**REQUEST**

Current Zoning: ML-2 (manufacturing and logistics, 2)  
Proposed Zoning: TOD-NC(CD) (transit oriented development, neighborhood center, conditional)

Approximately 4.54 acres located in the southwest quadrant of the intersection of Wilkinson Boulevard and Remount Road, north of Parker Drive.

## PLANNING STAFF REVIEW

**DEVELOPMENT NOTES**

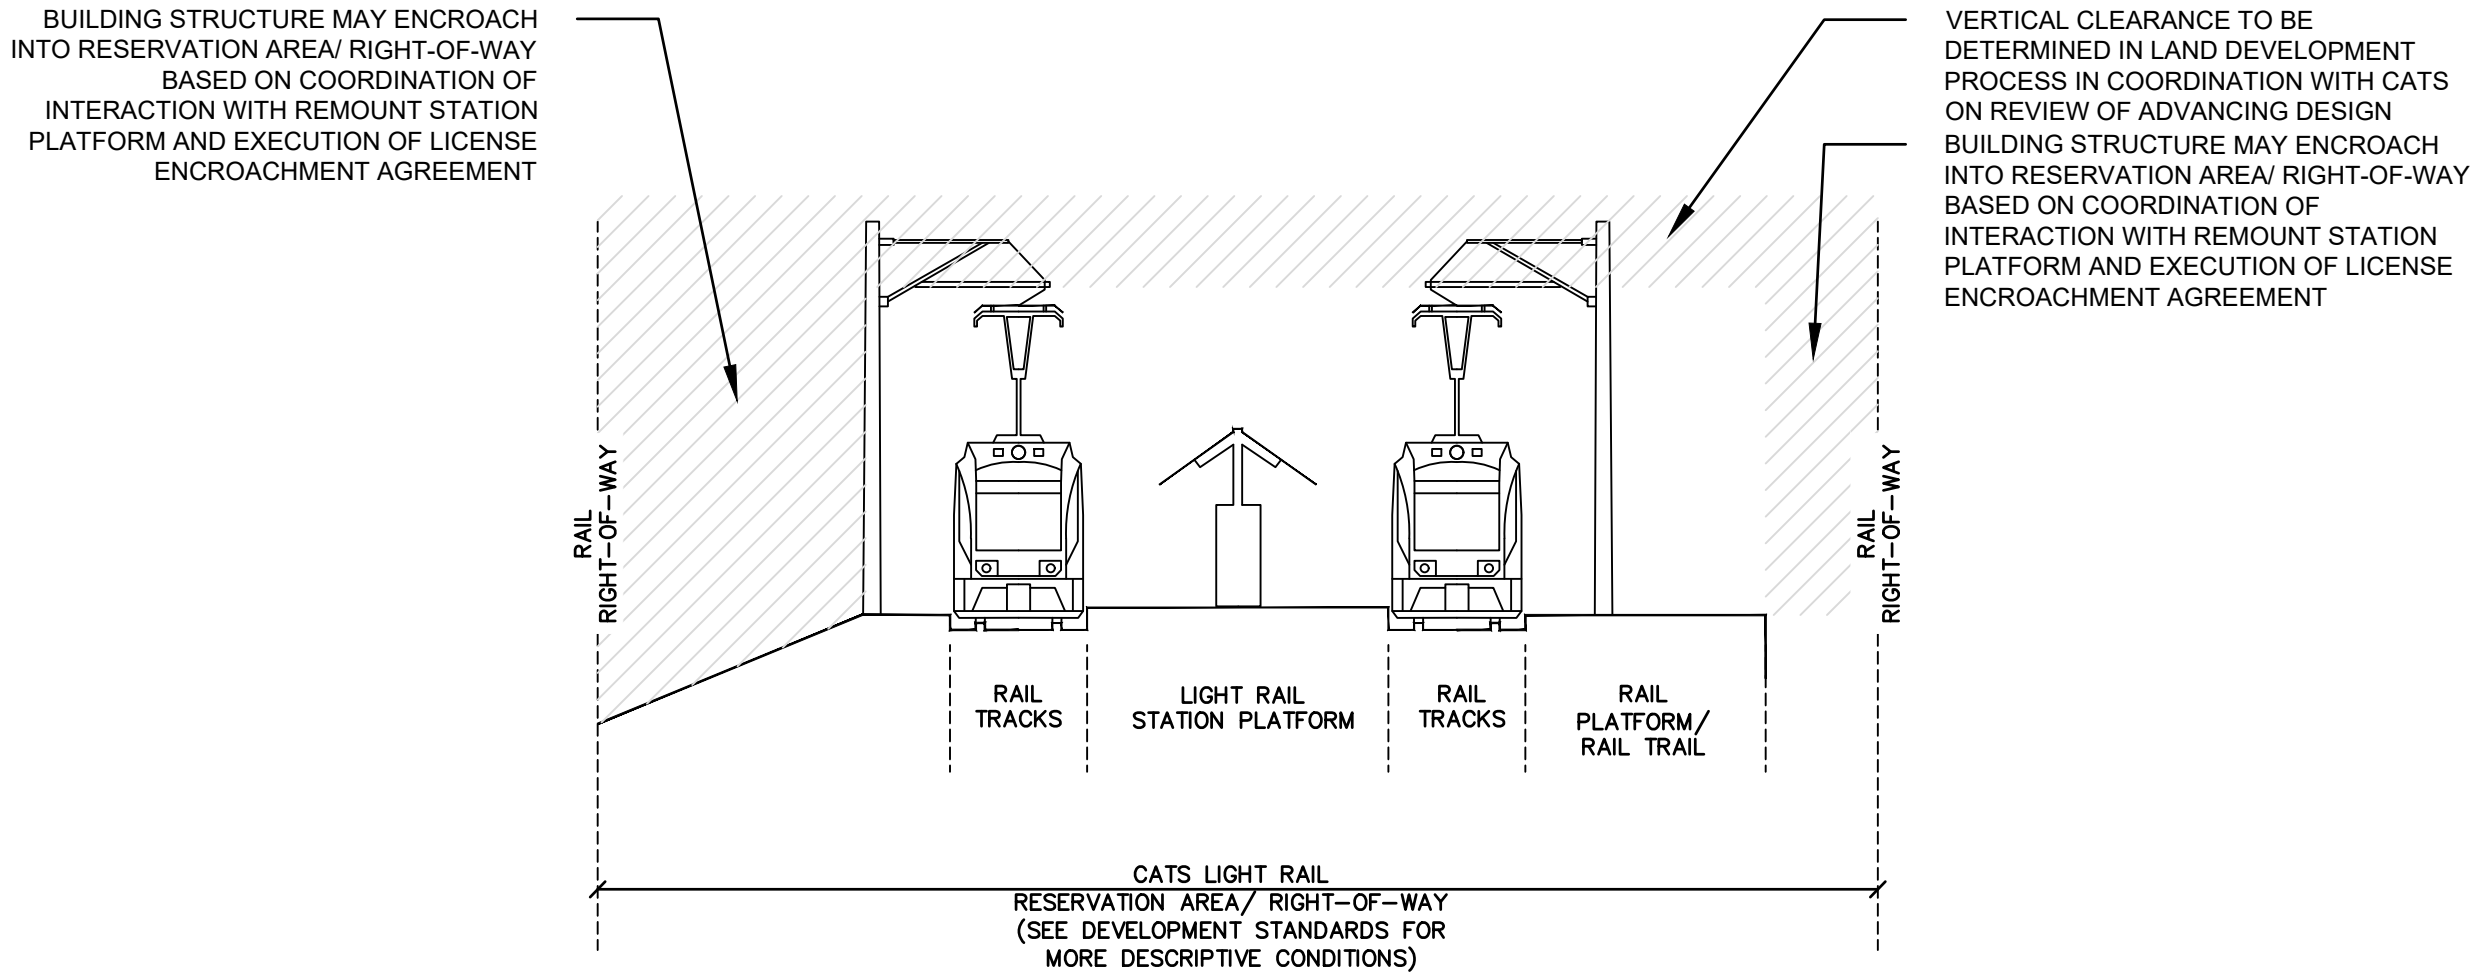
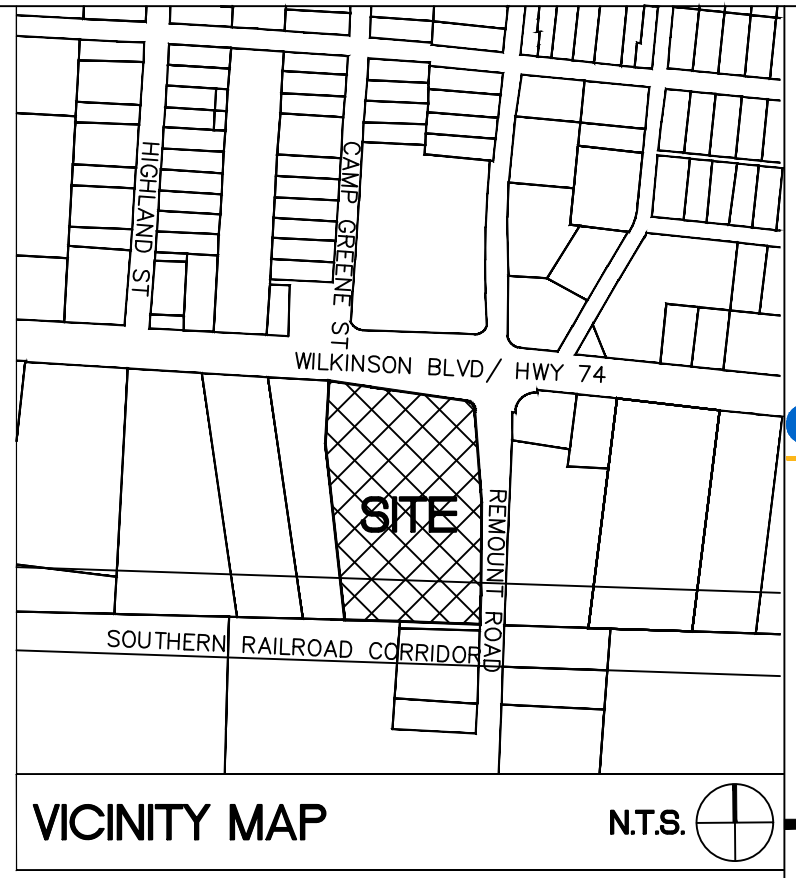
5. ~~Agree to resolve utility conflicts to accommodate public transit infrastructure.~~ **Addressed**
6. ~~Replace note H of section 3 (Reservation of CATS Right of Way) with language from 32.3G of the UDO.~~ **Addressed**

7. ~~Replace note A of section 3 (Reservation of CATS Right of Way) with language provided by CATS.~~ **Addressed**

- 8. ~~Replace note C of section 3 (Reservation of CATS Right of Way) with language provided by CATS.~~ **Addressed**
- 9. ~~Per the CATS request, commit to installing active uses at the transit station level.~~ **Addressed**

- 10. ~~In Note F of section 3 (Reservation of CATS Right of Way) modify the language to note, "...but excluding automobiles and trucks authorized by the City...".~~ **Addressed**

- 11. ~~Revise the wording in (b.) in section 3 — Reservation of CATS Right of Way to read, "...public transit infrastructure in compliance..."~~ **Addressed**
- 12. ~~Revise the wording in (C.) in section 3 — Reservation of CATS Right of Way to read, "...the actual loading and dimensions may be modified..."~~ **Addressed**
- 13. ~~Revise the wording in (A.) in section 3 — Reservation of CATS Right of Way to read, "...to be incorporated into the building provided that the desirable clearance between..."~~ **Addressed**

RZ - 200

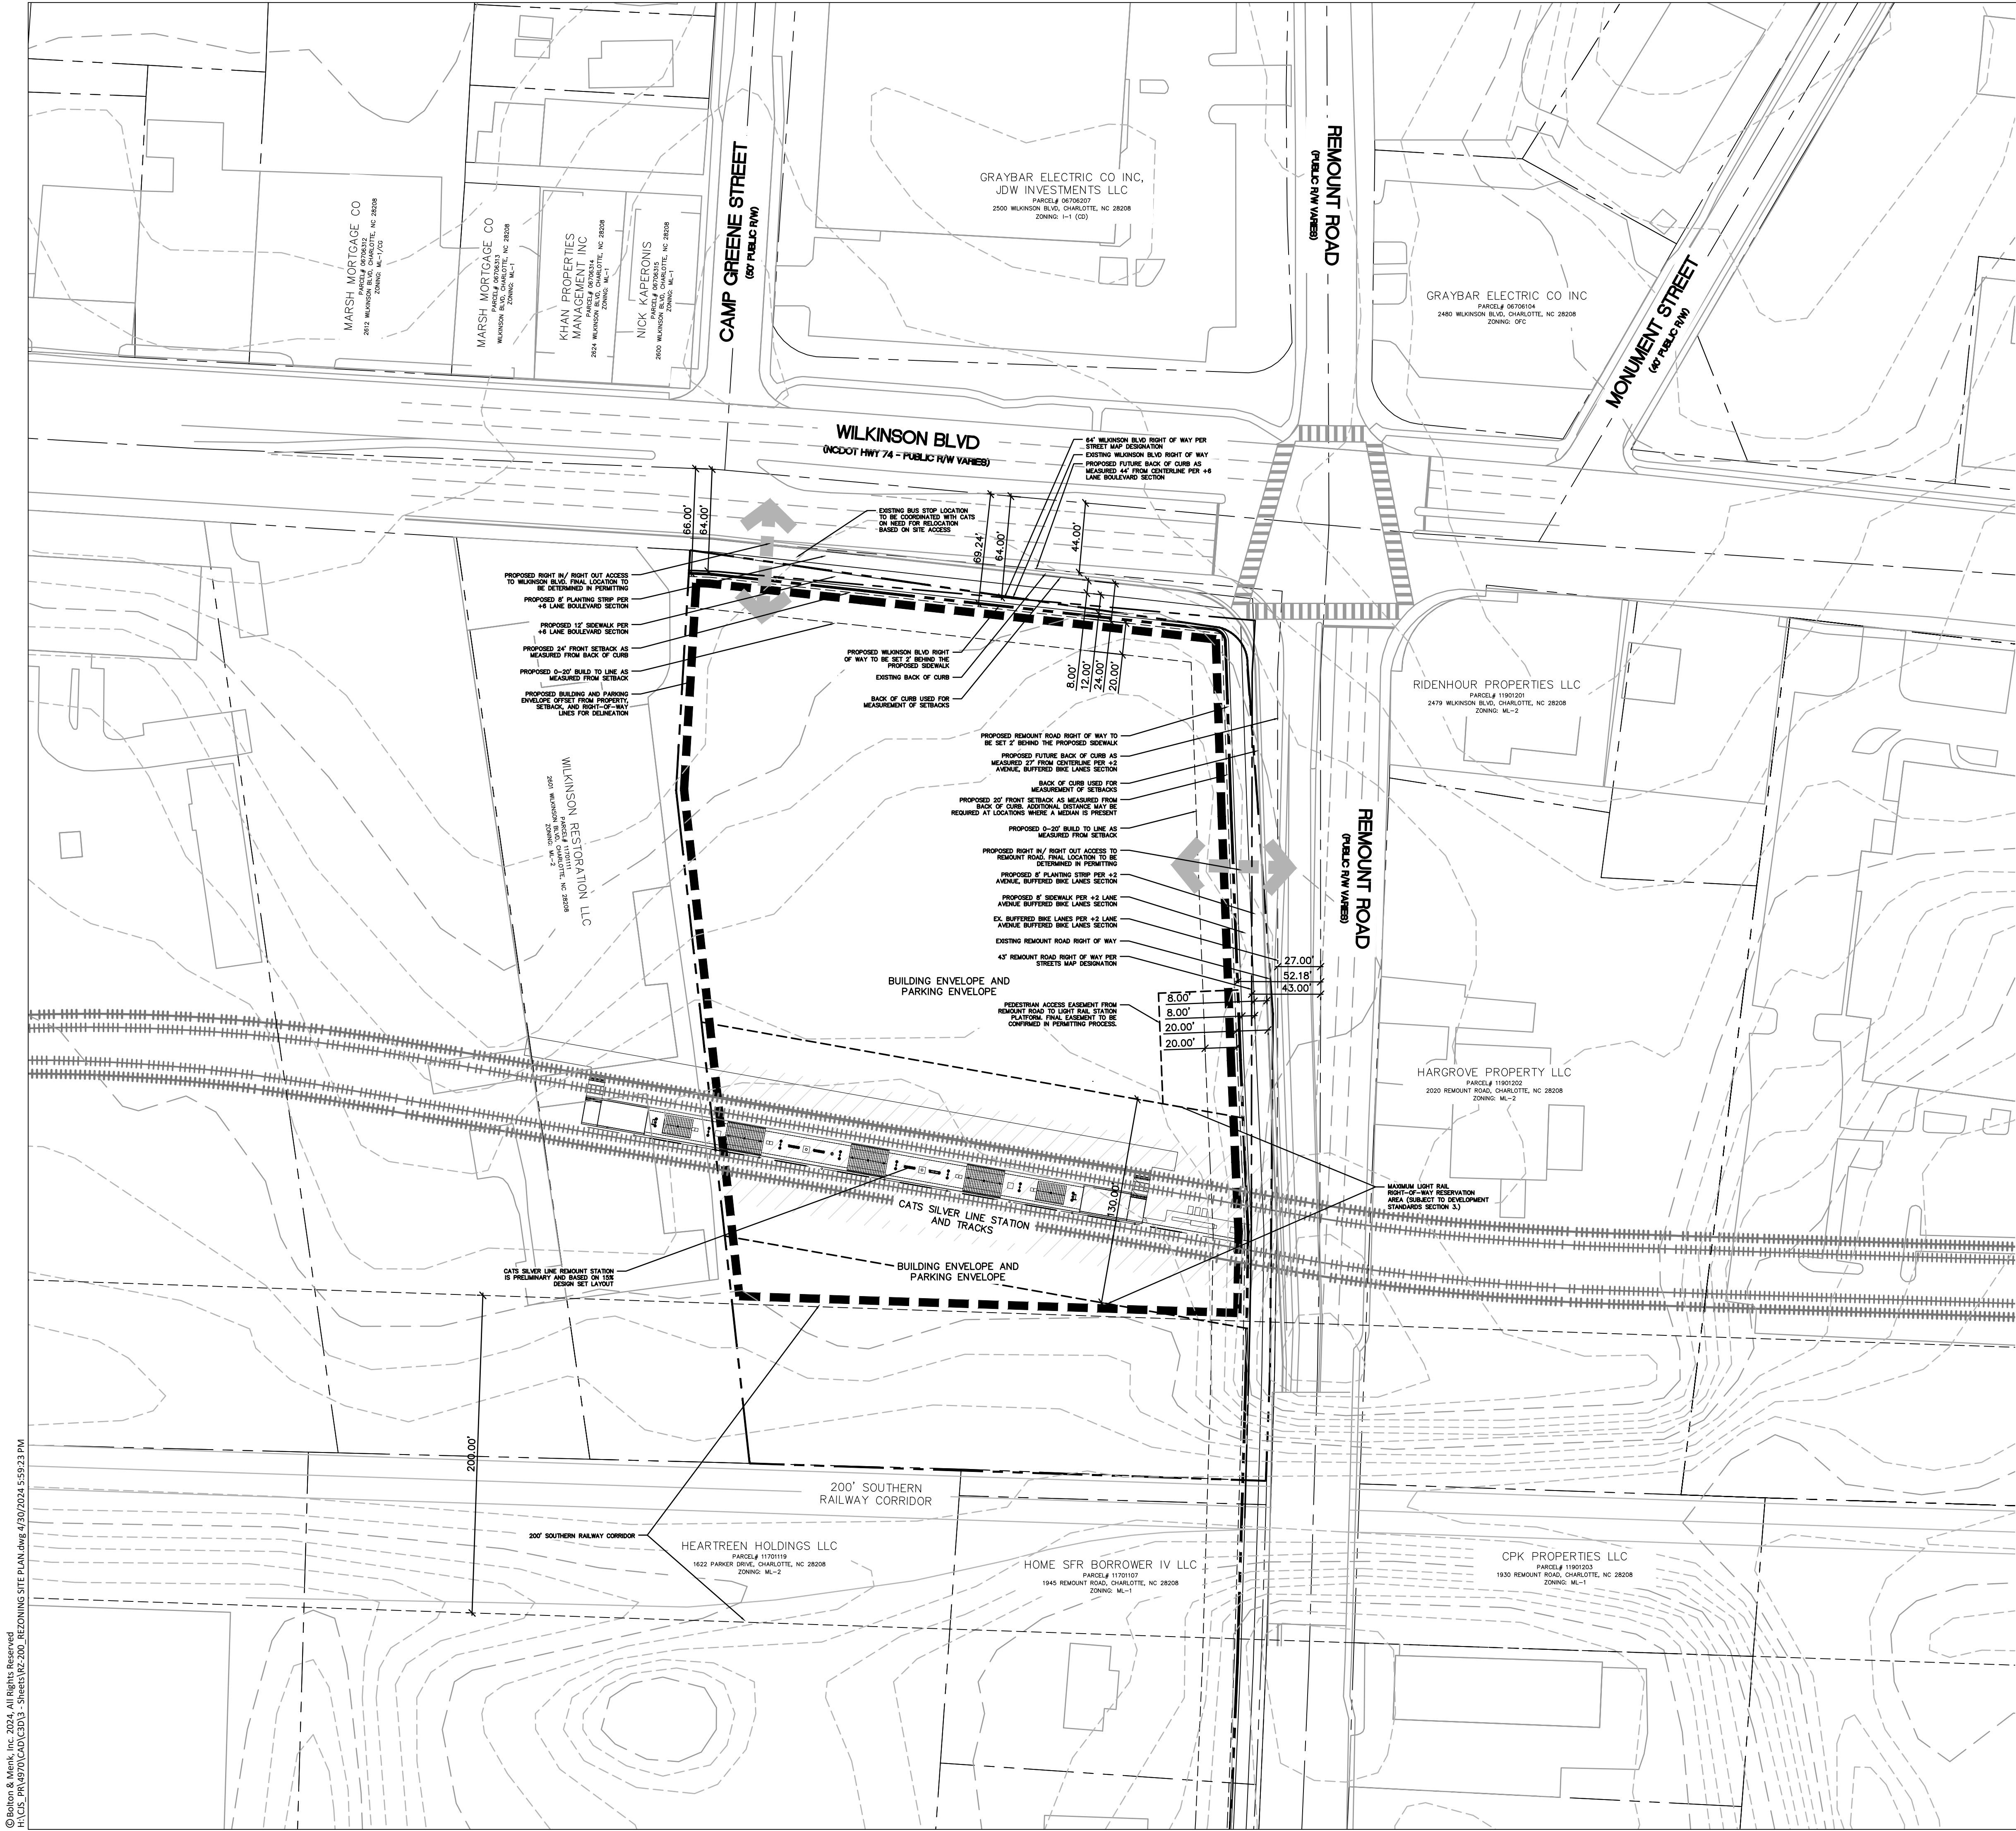
2. ~~Revise the site plan to dimension and label the right-of-way from the road centerline.~~ **Addressed**
3. ~~Modify the width of the reservation area from 85' to 130'.~~ **Addressed**
